Falcon Highlands

Final Drainage Report

24004308

Provide PCD file No.
SF2418

CLIENT	CHALLENGER HOMES
DATE	07/08/2024 - KMB
REVISIONS	
COUNTY FILE NO.:	
DR. TN	CH. KB
P.M. DM	
JOB	24004308
SHEET NO.	3

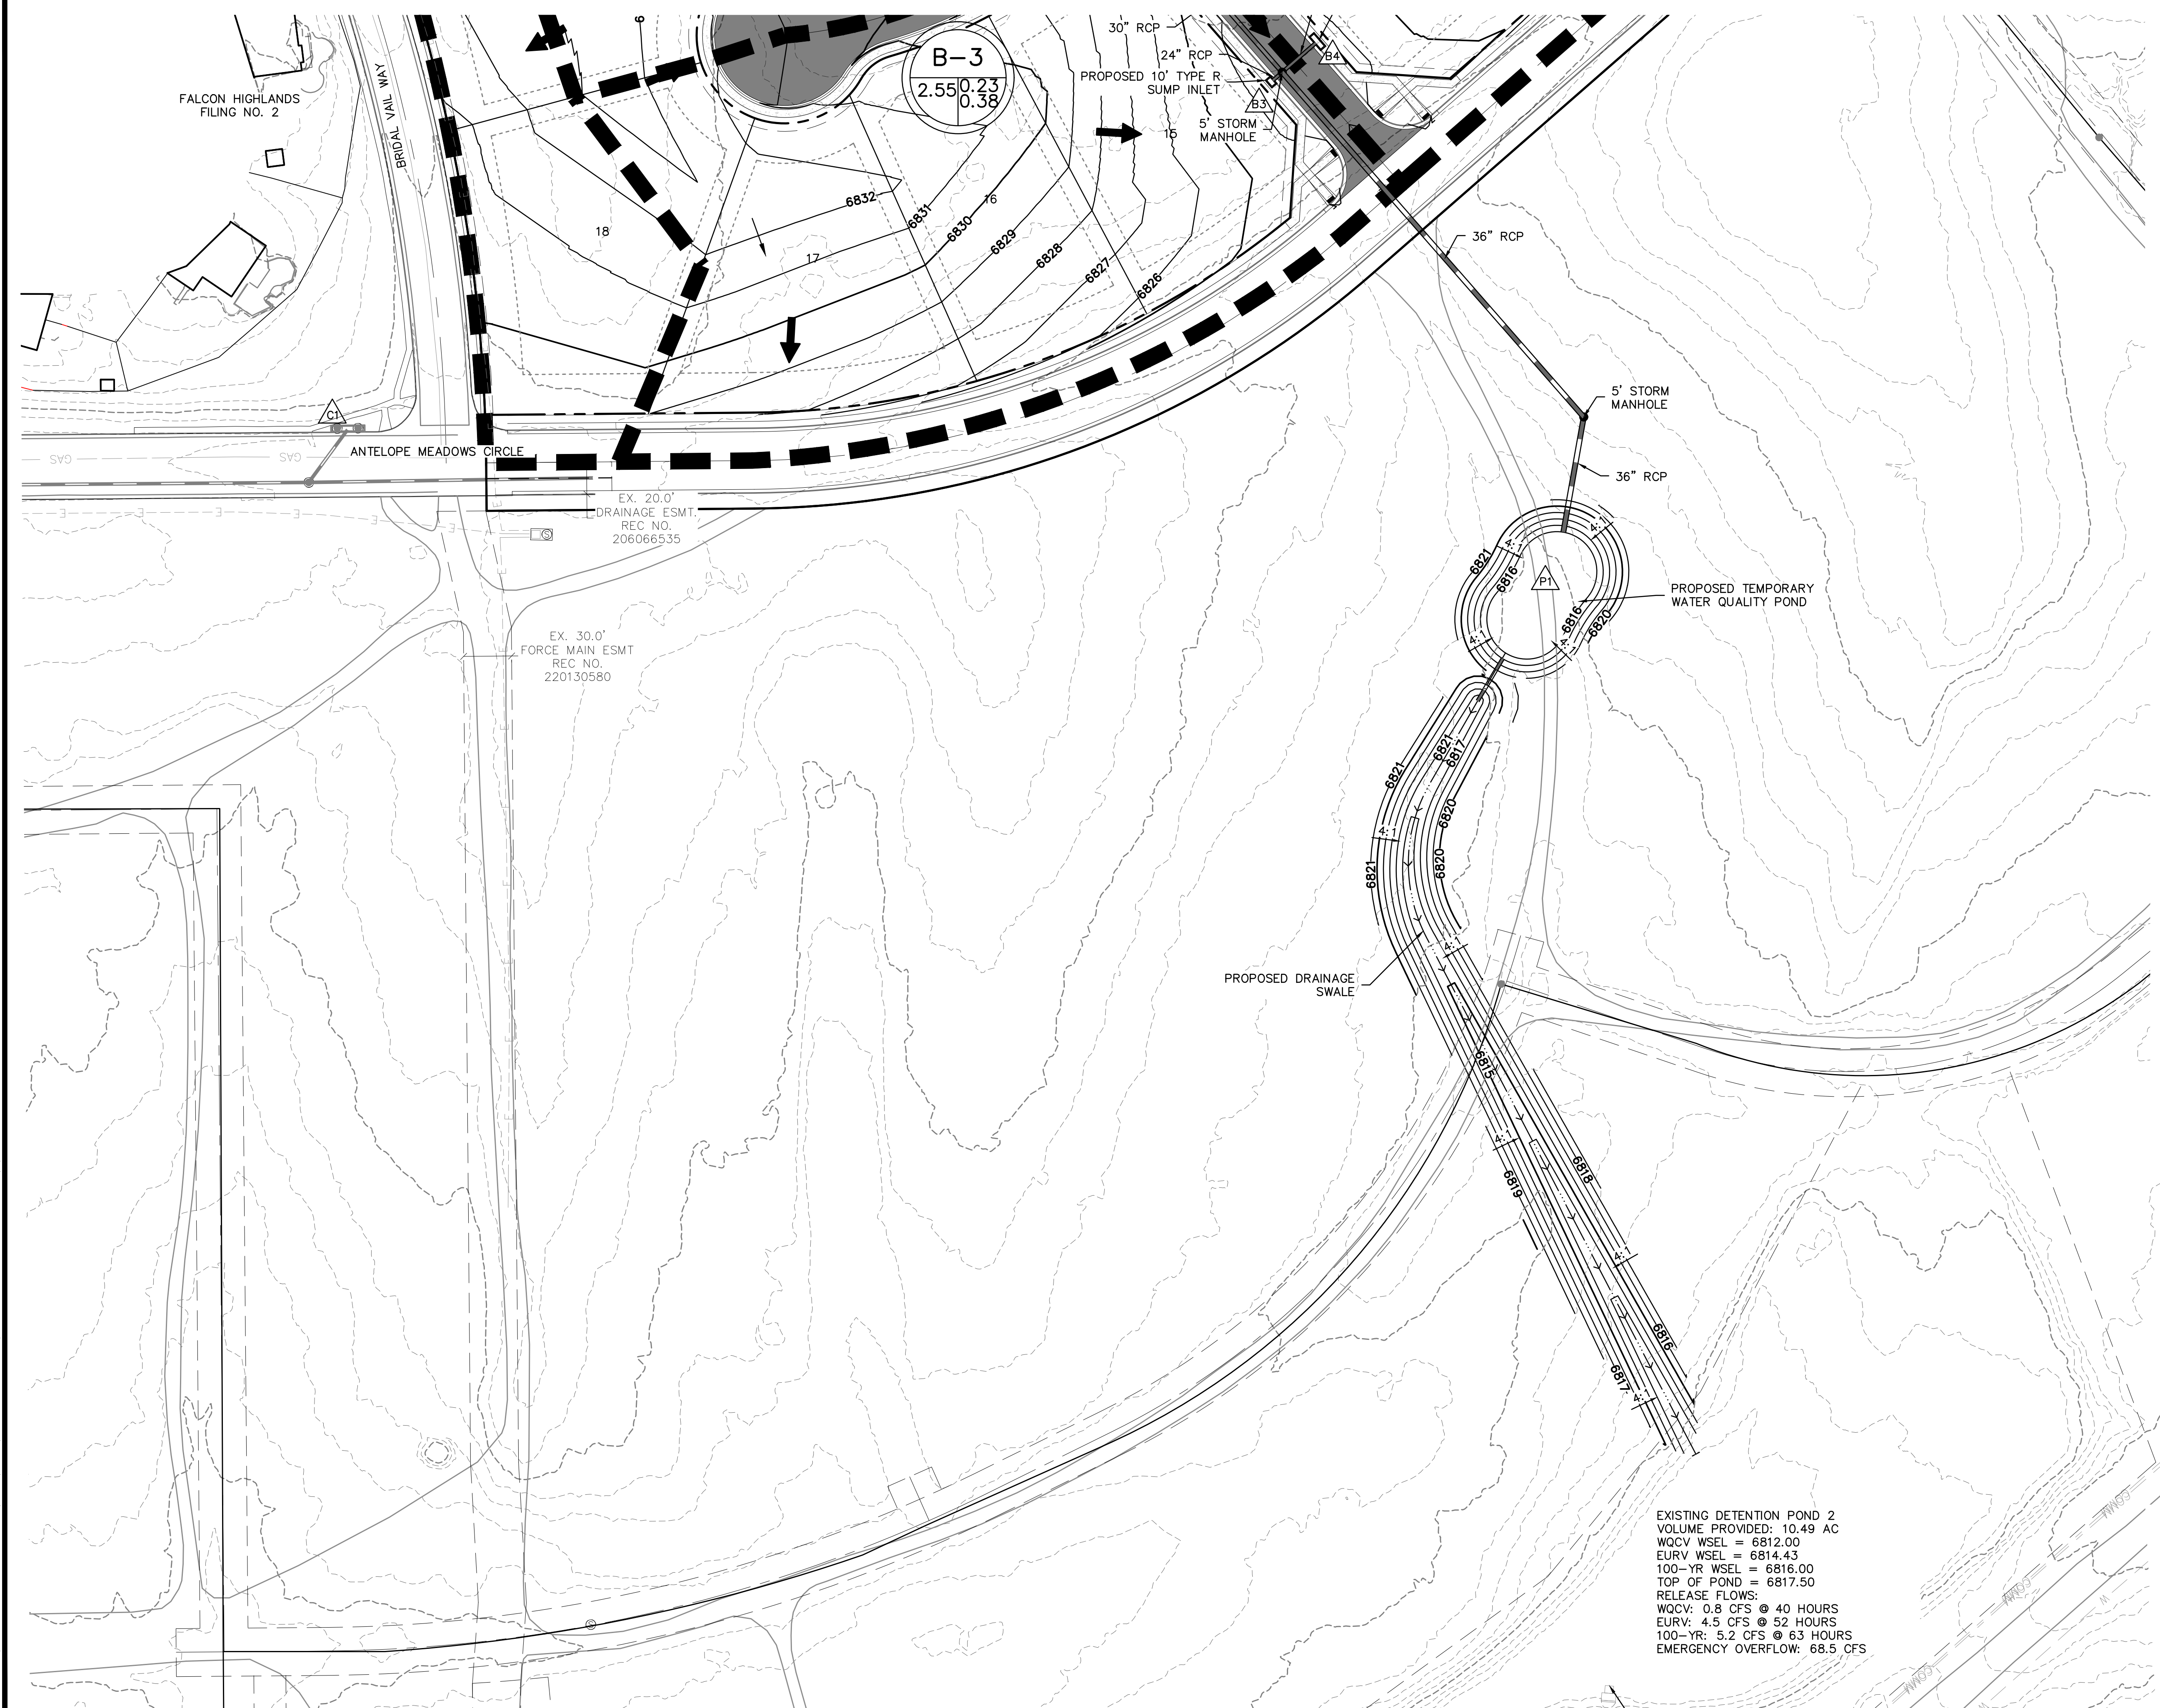
Existing detention pond 2 is not full-spectrum or built to County standards. If this facility is providing detention for the site it needs to be brought to current County standards. See below excerpt from the PUDSP225 DR

The pond is called a water quality pond in many places throughout this report. How is it providing full spectrum detention? Elsewhere it is stated that larger storms overtop the pond. It should not be called a detention pond or full-spectrum if it is not sized to the full-spectrum criteria. The proposed pond also does not capture flows from basins A-1 or C-1 so it needs to be clarified/stated which basins this pond is treating.

Because this project is not temporary, such as an early grading project, a temporary facility is not sufficient. Even if the proposed facility is only treating water quality it needs to be designed to current County standards including trickle channel, micropool, maintenance roadway, etc.

Per meeting with El Paso County dated October 16, 2024 it was determined that Atwell would be required to redesign existing ponds 1 and 2 to meet current El Paso County Standards. Due to this, the drainage design and report have been completely updated to account for this redesign. This note will be referenced throughout the comment response where there have been major changes to the report.
